272 Lancaster Street Permit 2017-01251

I am currently reviewing your project for verification of compliance with the State of Maine and City of Portland Fire and Life Safety NFPA Codes and need the following information to complete my review:

**SECOND FLOOR PLAN**

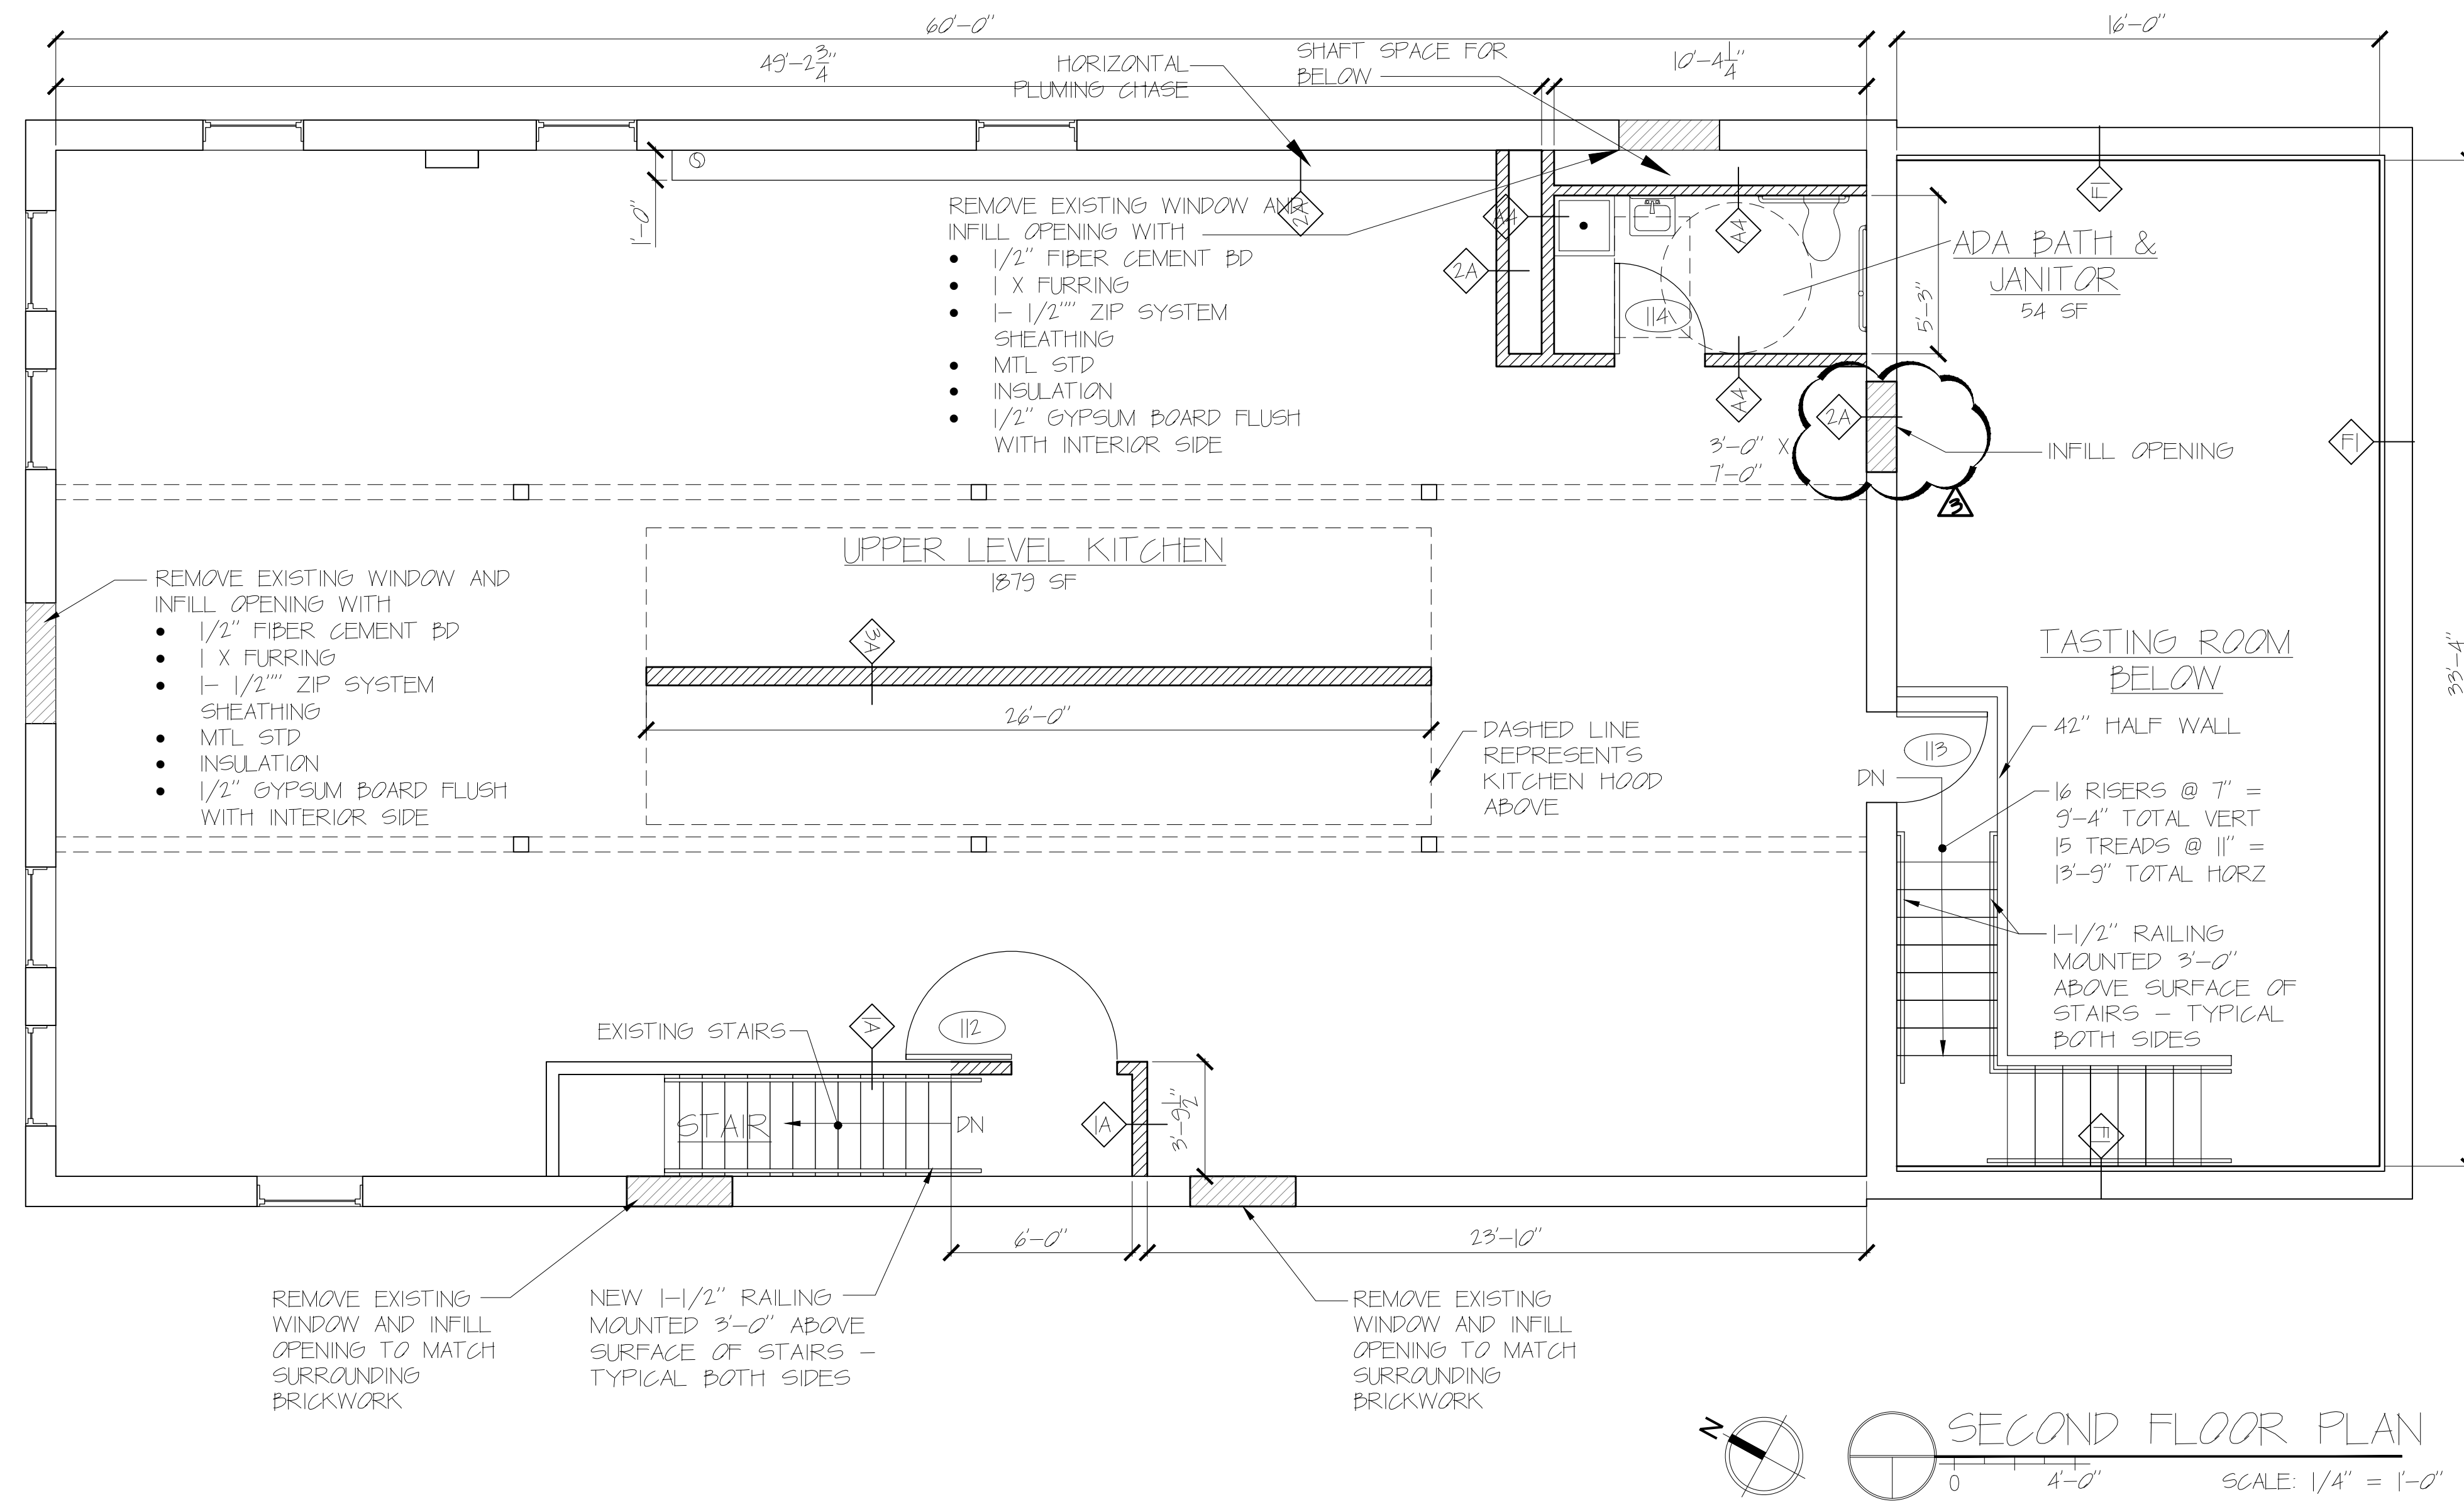
1. Mark on the floors plans where the proposed wall opening and lift will be.
2. The proposed addition seem to have limited headroom height on the 2nd floor. Please show how good will be moved from the lift area to the second floor. Will personnel need to enter the lift area?
3. Will the new wall openings have door or guards around the openings? Please provide a detail on these.

It's good to hear that the project is moving along in Portland's pipeline! I have cc'd Jim DeZutter to this email who is the project lead and Sylvan Juarez our Architect for any extra help needed. That said, I have attached the updated versions of A1.1 and A1.2 which shows where the lift will be on the floorplan. There will be no humans entering the area where goods are lifted. The materials lift has a platform where goods are placed without humans stepping inside the lift, therefore headroom will be unaffected. I have attached SK1 and SK2 which detail the opening guards. Any details you require on the doors can be answered by Asa Gorman for materials and scope or Sylvan if drawings are required.
